Consultee Comments for Planning Application

Application Number: 23/06156/COND

Address: 464 Shadwell Lane Leeds LS17 8BA

Proposal: Consent, agreement or approval required by condition 4 to planning application 18/07119/OT

Proposed Drainage Plan  
1 : 100

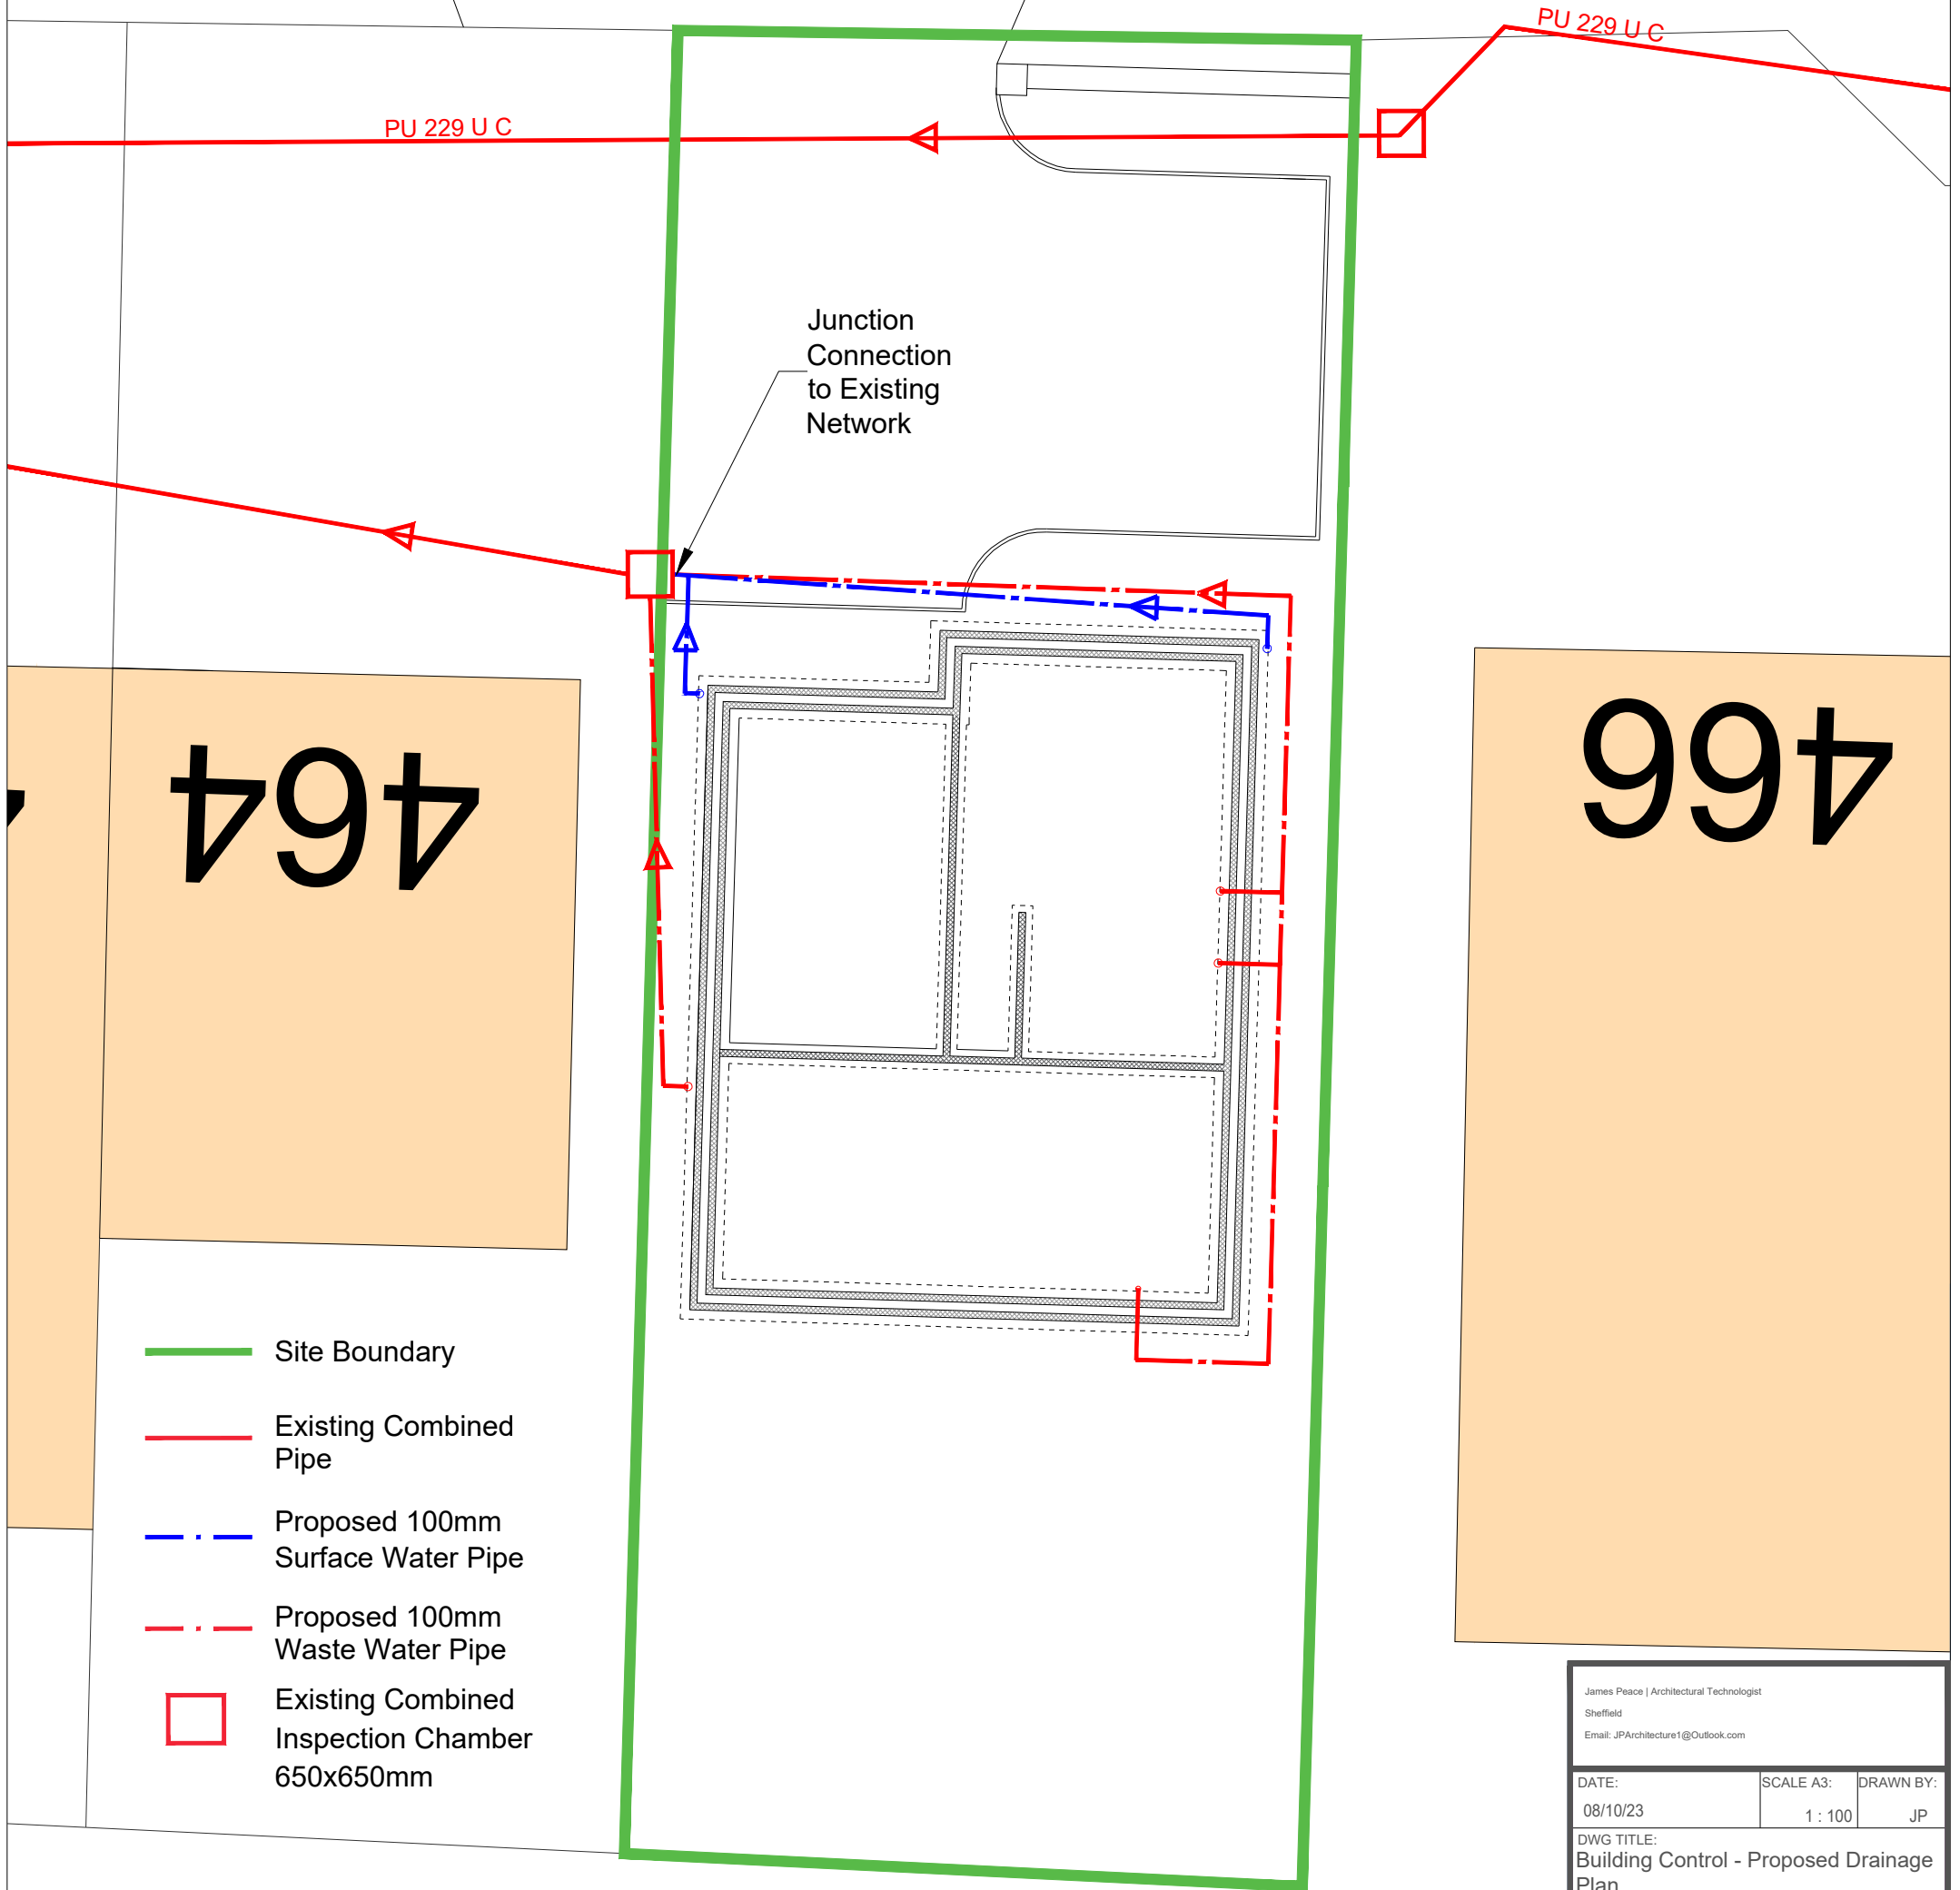
a) The Drainage Strategy does not meet the requirements of Leeds City Councils Minimum Development Control Standards for Flood Risk. <https://www.leeds.gov.uk/planning/planning-policy/adopted-local-plan/natural-resources-and-waste-local-plan/minimum-development-control-standards-for-flood-risk> and the drainage information to be submitted shall be as set out within the Leeds FRM Validation Requirements for Flood Risk and Surface Water Drainage

FRM await the required information and at present, are unable to support the discharge of Condition 4.
